CITY OF ALBUQUERQUE

May 7, 2019

Re: Being there live-work duplex
1315 Mountain Road NW
Traffic Circulation Layout
Engineer's/Architect's Stamp **04-23-19** (J13D210)

TCL-1

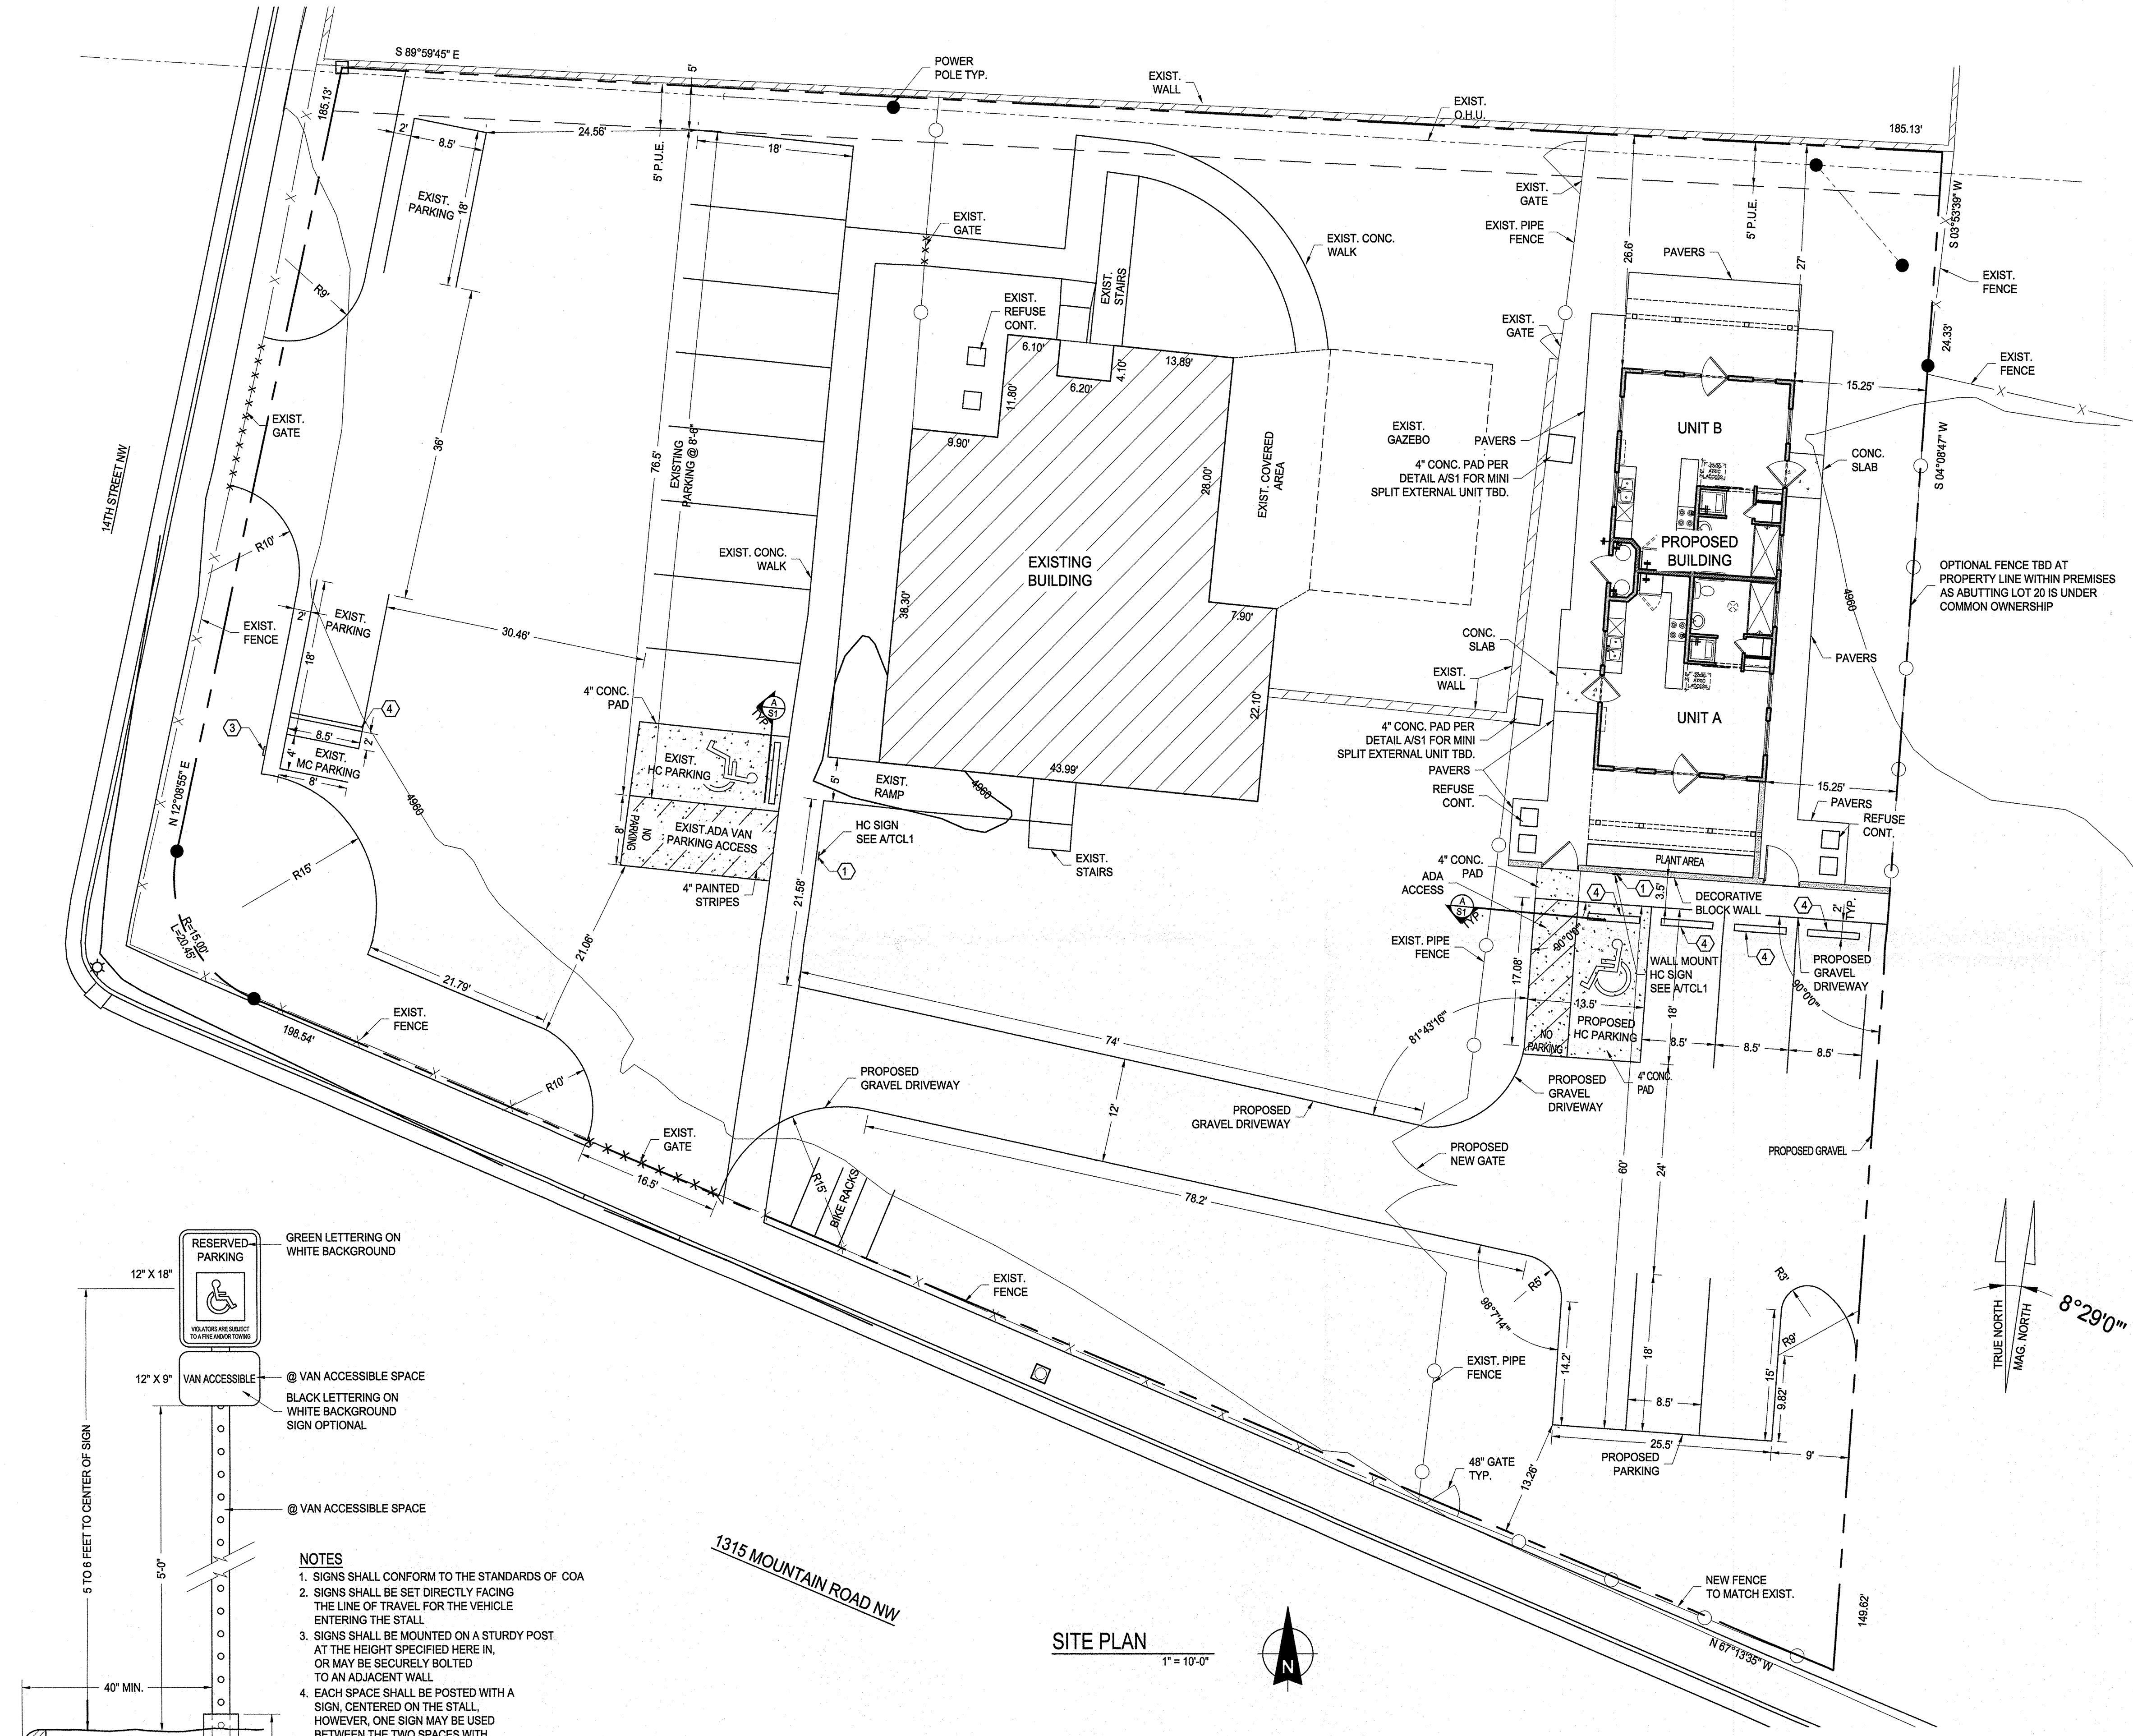
1. The ADA accessible parking sign must have the required language per 66-7-352.4C NMSA 1978 **"Violators Are Subject to a Fine and/or Towing."** Please call out detail and location of HC signs.

2. The ADA access aisles shall have the words **"NO PARKING"** in capital letters, each of which shall be at least one foot high and at least two inches wide, placed at the rear of the parking space so as to be close to where an adjacent vehicle's rear tire would be placed. (66-1-4.1.B NMSA 1978)

3. Per DPM, a 6 ft. wide ADA accessible pedestrian pathway is required from the HC parking stall access aisles to the building entrances. Please clearly show this pathway and provide details.

4. Service vehicle and/or refuse vehicle maneuvering must be contained on-site; provide a copy of refuse approval.
5. A hard driving surface will be required as part of this proposed project for ADA parking area.

6. Please include one copies of the traffic circulation layout at the next submittal.
7. Motorcycle parking spaces shall be designated by its own conspicuously posted upright sign, either free-standing or wall mounted per the zoning code.

8. Please provide a 6" by 8" concrete barrier between the motor cycle parking space and the regular car parking space because of the way they are designed.
